Application no: H16-0704-11

Description: Details of existing and proposed site levels, surface water disposal, affordable housing, cycle storage, external lighting, external meter boxes, cycle racks and landscaping (Conditions 2, 4, 5, 7, 8, 10, 11 and 12 of H16-0623-10 - Conditions 2, 4, 8 and 10 relate to Plots 101-142 only)

Location: Wygate Park
Spalding
Lincs
PE11 3LE

Amendment: Amended proposed cycle rack storage (Email, Statement and 2 Specification Sheets)

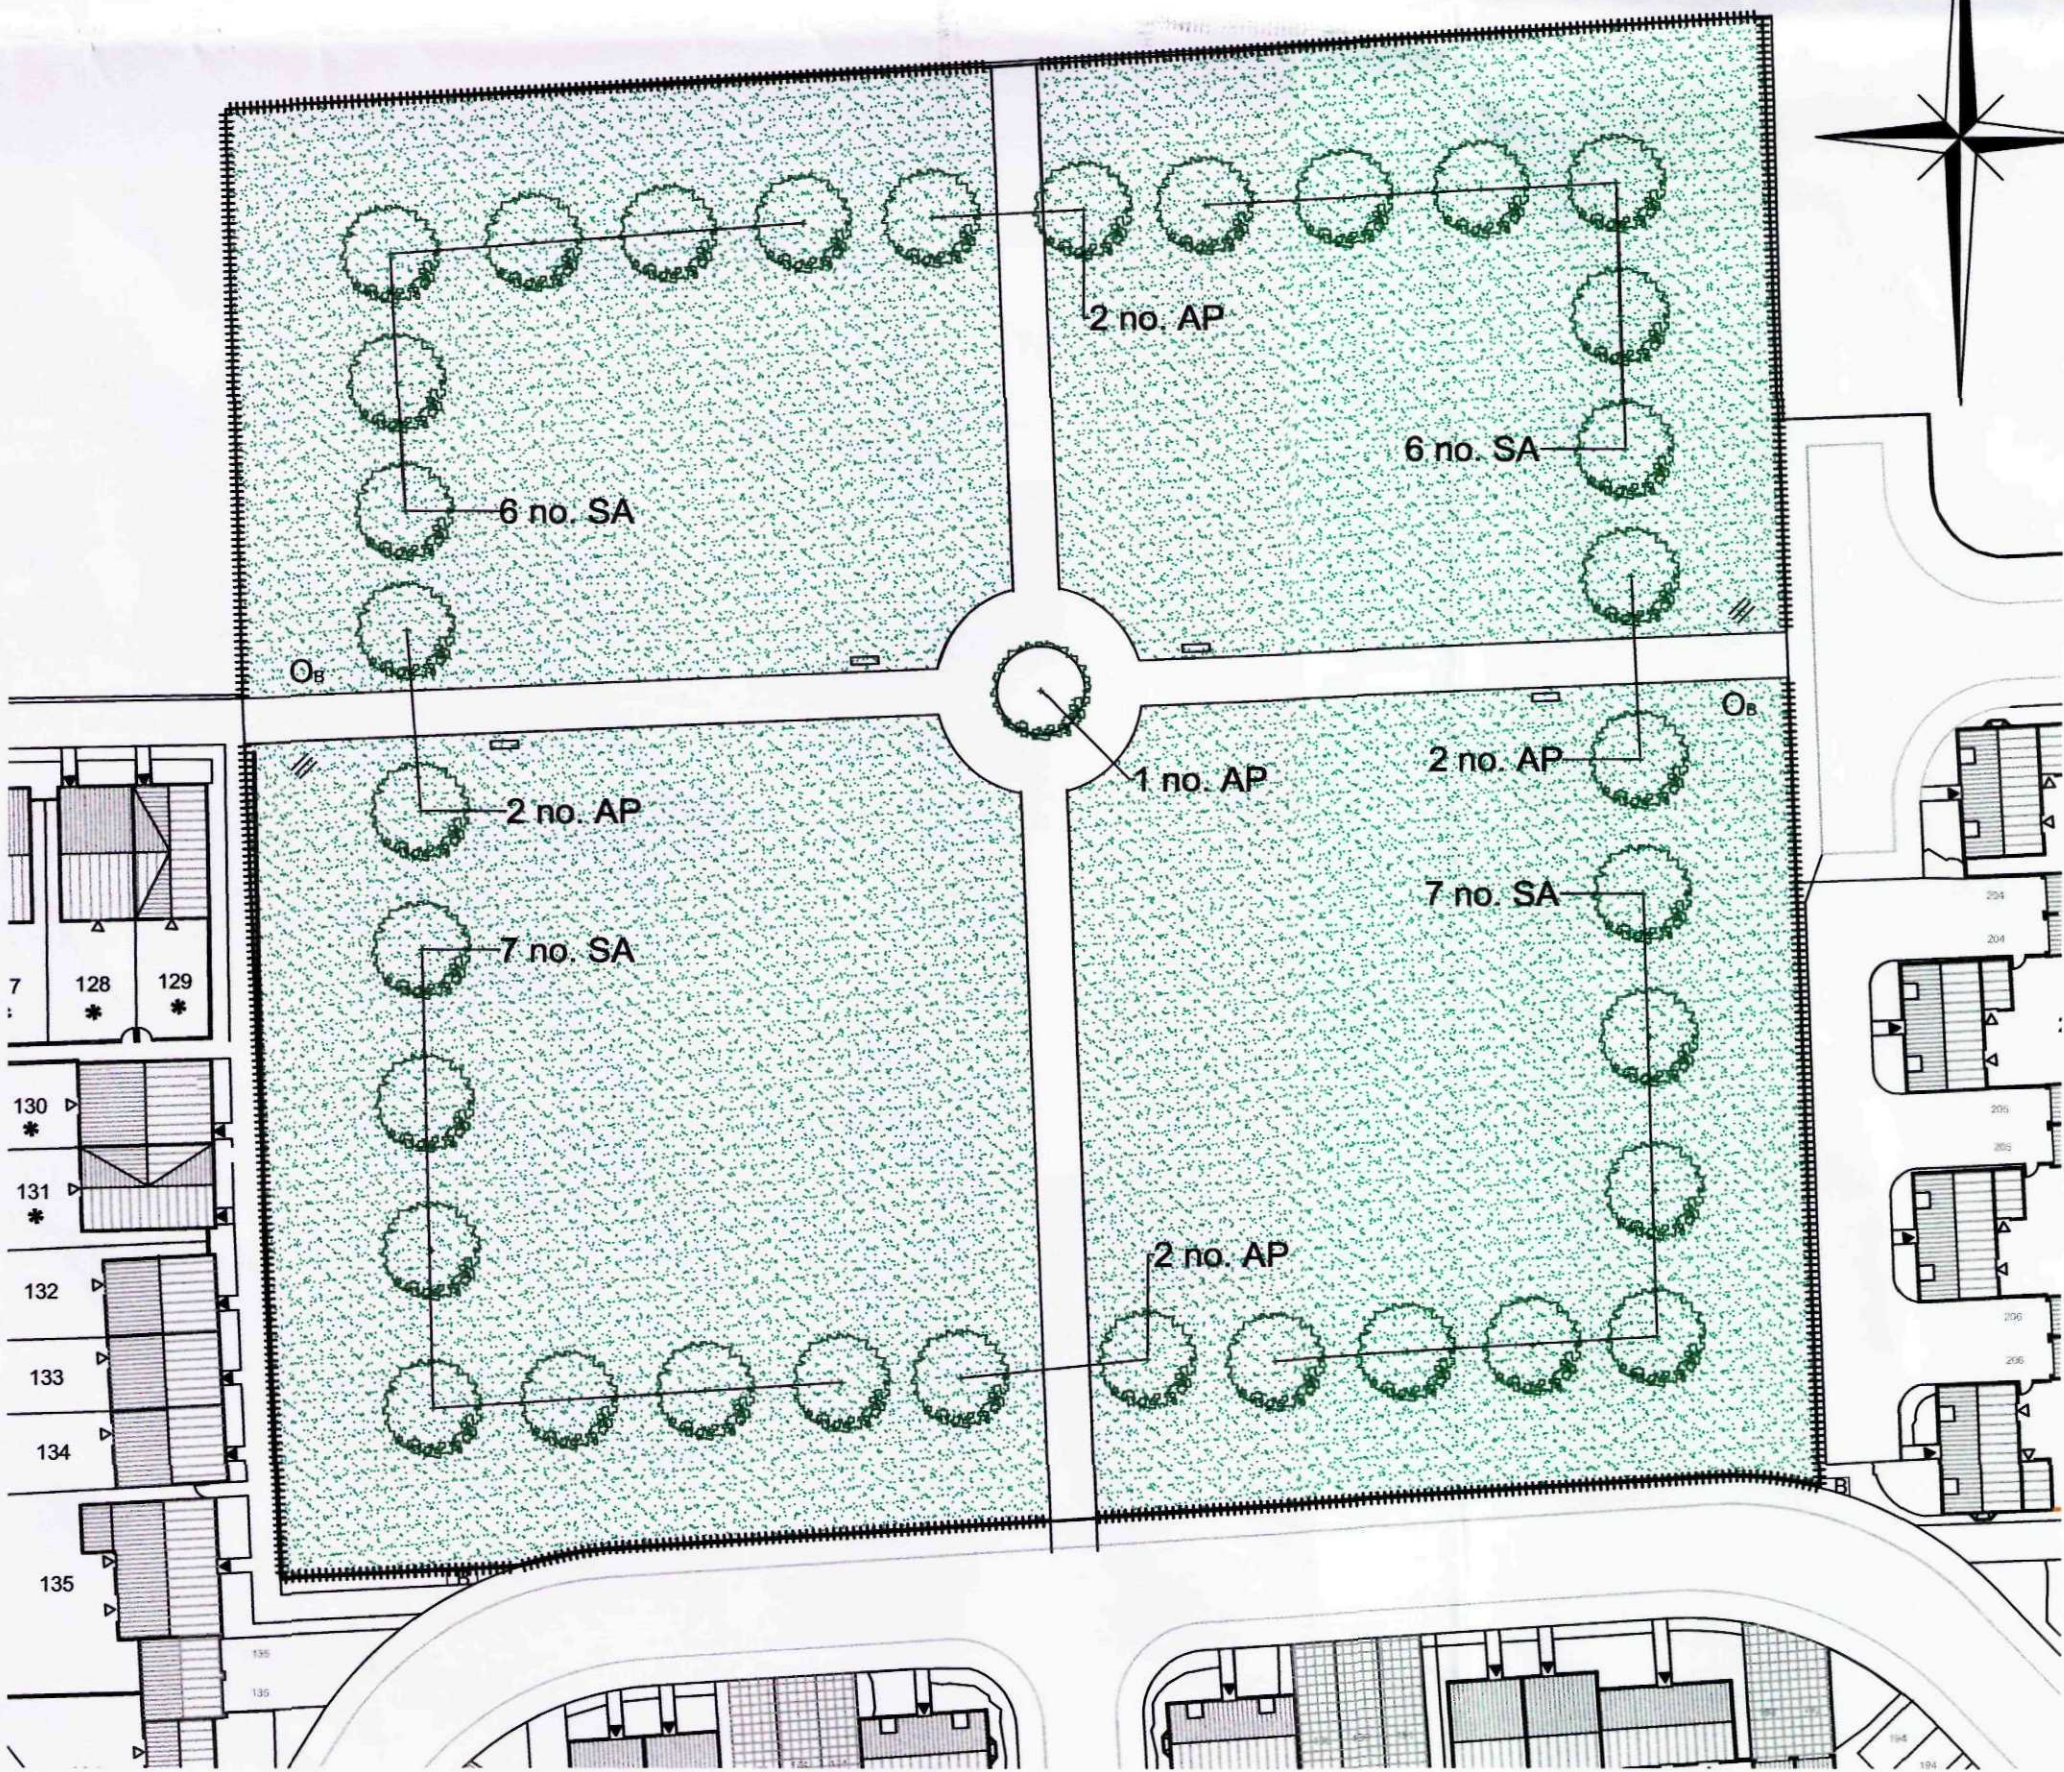
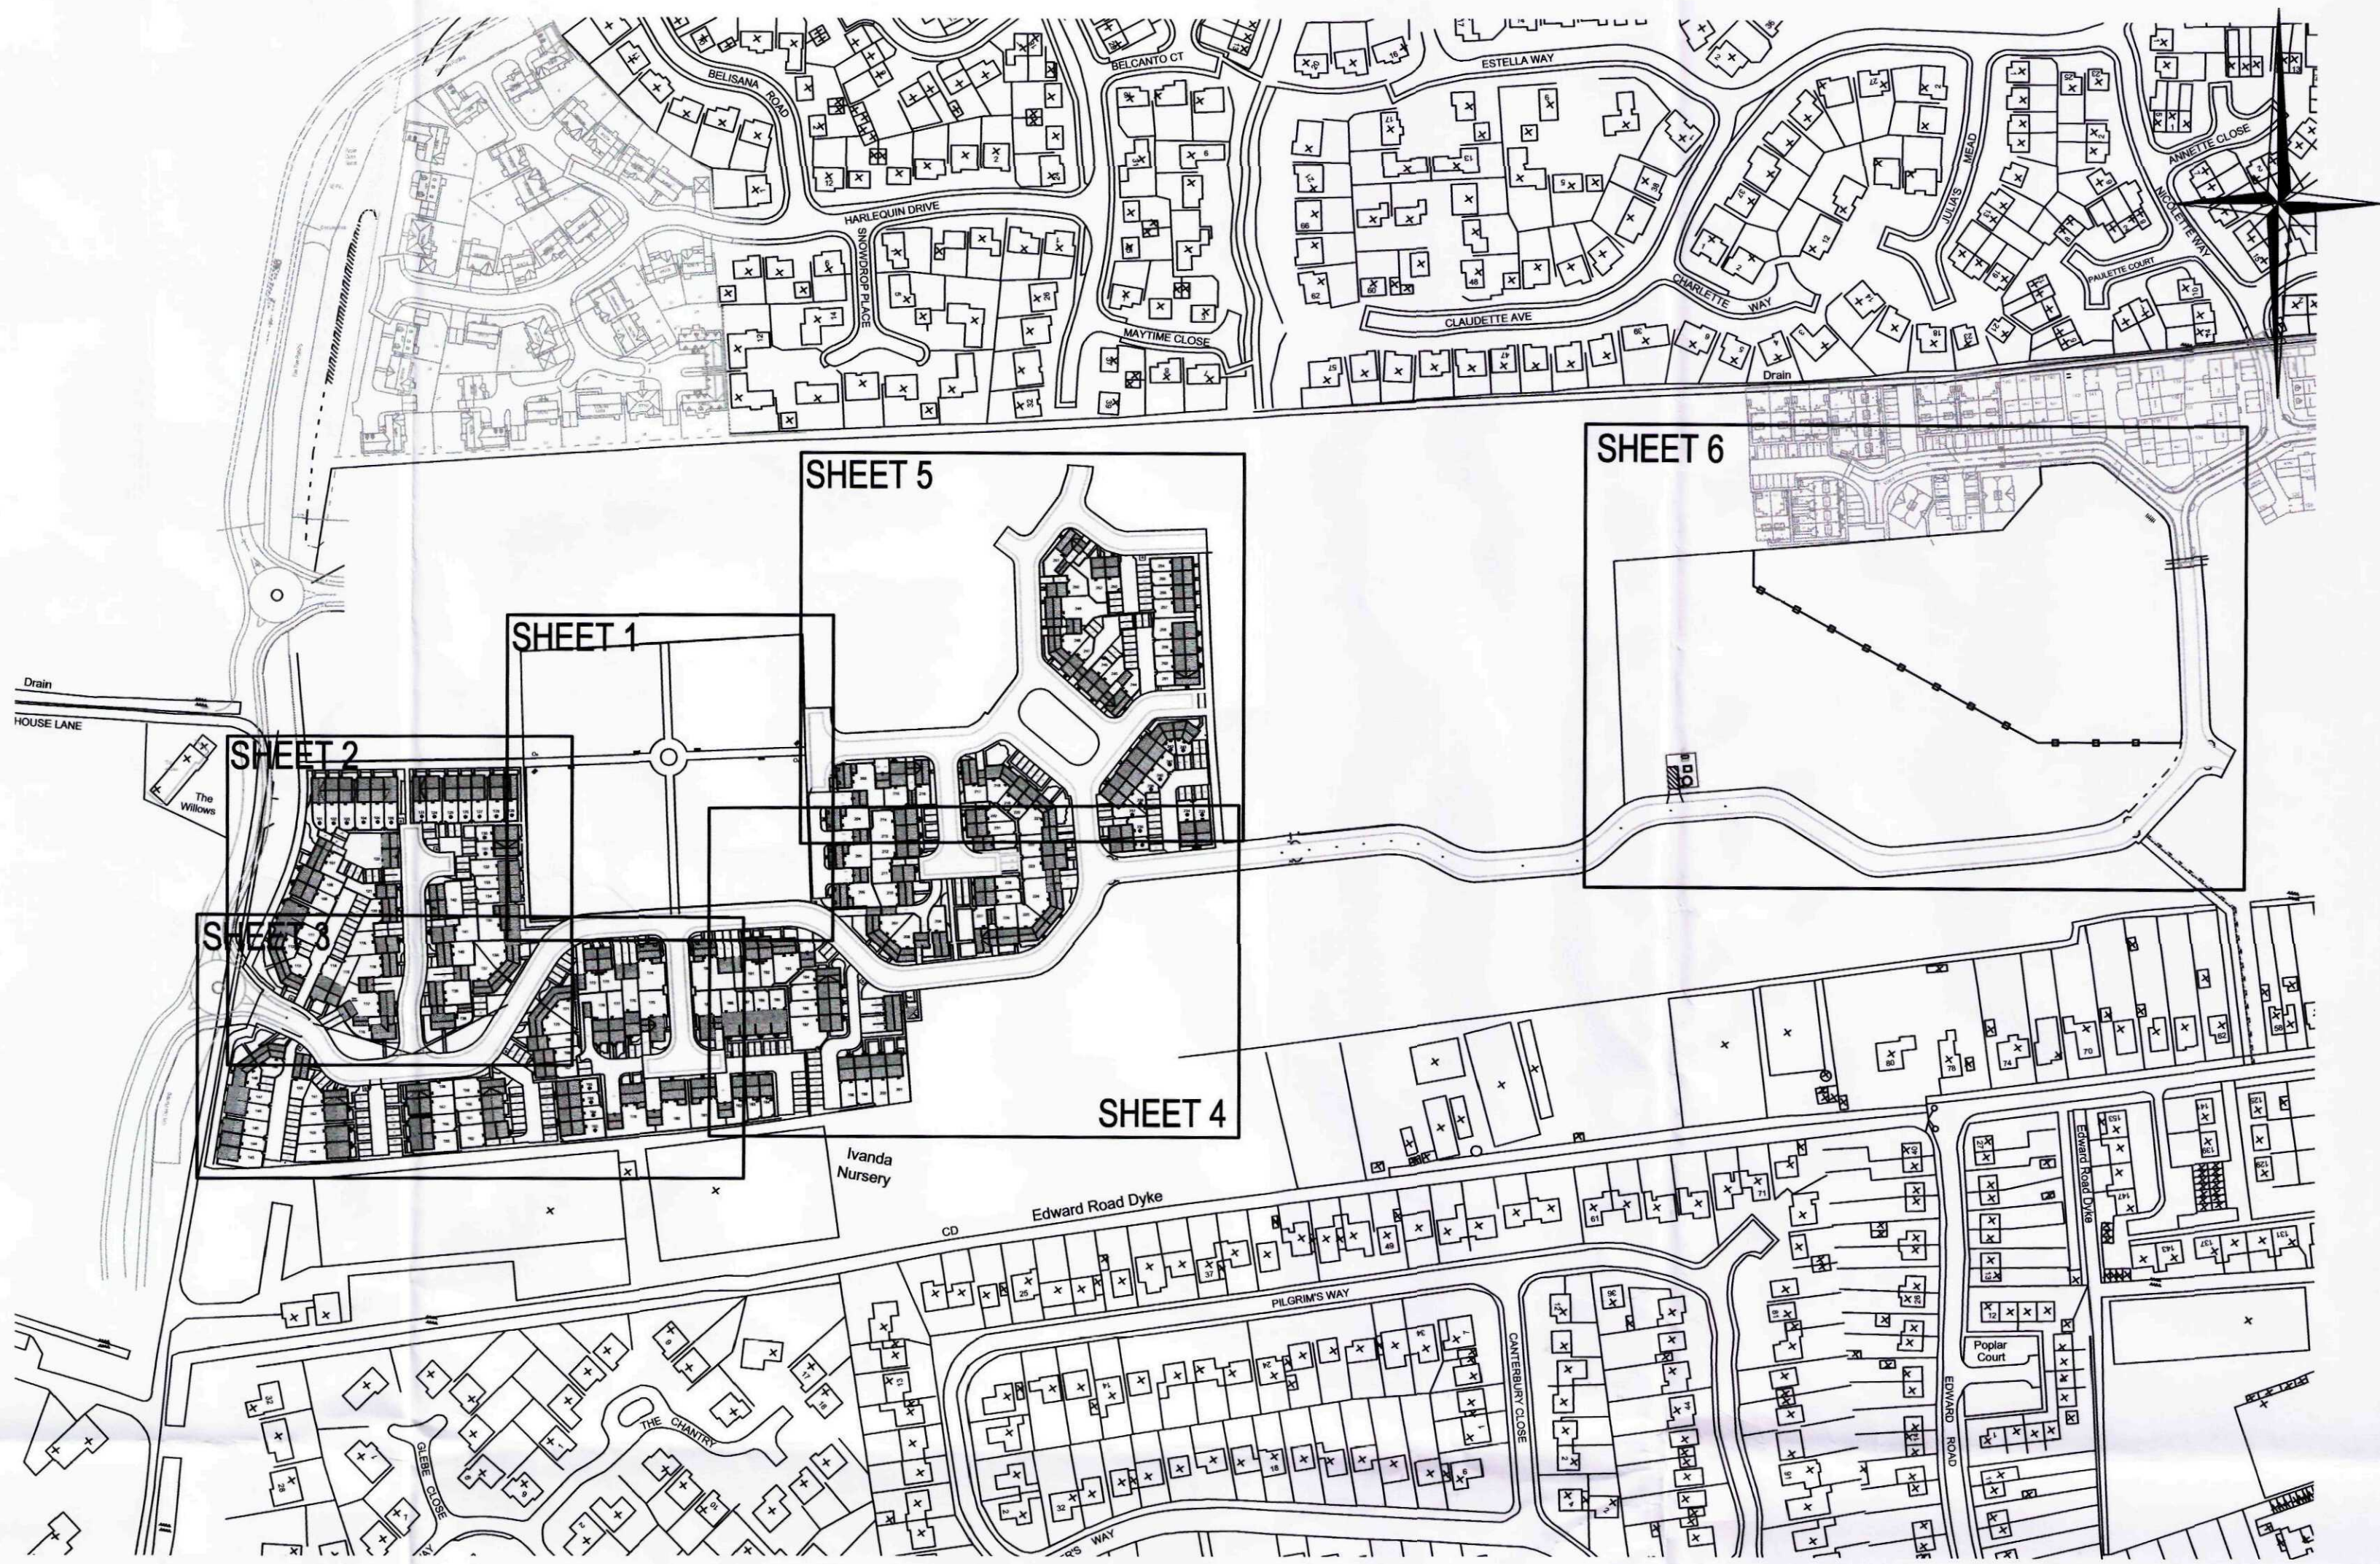
PEDALS have objected on 2 grounds, the letter is available to view on the website. Specifically for the cycle parking at the public open space these should be "Sheffield" type stands.

Further to your comments we have now amended the proposed cycle rack storage scheme as attached. We have accepted Pedals recommendation regarding the Sheffield stand for the open space cycle storage but do not feel able to accommodate a covered cycle area for each individual house. Please note that we will be providing covered cycle storage for all the affordable units which results in 36% of the current phase 1 application being provided with covered storage but we do not feel it practical to provide a covered area for all the private houses.
